From: <permitnow@gmail.com>
To: Christina Stacey <cstacey@portlandmaine.gov>
Date: 9/9/2015 10:32 AM
Subject: Re: Permit #1840 - 55 Riverside St (Mobil station)

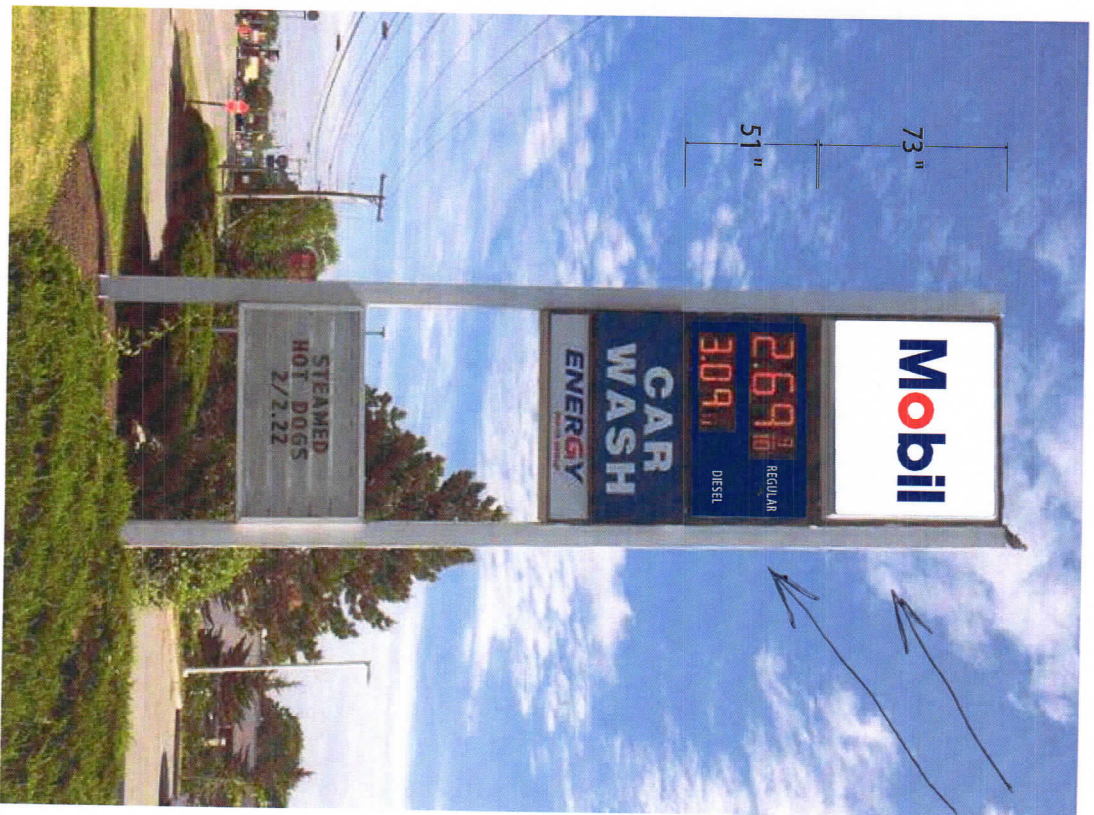
> I had a quick question about the sign permit application you submitted for the above-referenced property. In the current application, the "Car Wash" section of the pylon sign is noted as 36" high and the "Energy North Group" section of the pylon sign is noted as 18" high. However, in the 2012 permit, the heights of these two sections of the sign are noted as 30" and 15", respectively. Can you confirm which are the correct measurements, and whether there has been any actual change in the size of these sign sections over the years? Because these are already non-conforming in size, it is important that we have accurate information.

The sizes have not changed , all sizes on free standing sign are what was approved in 2012. 30" and 15"
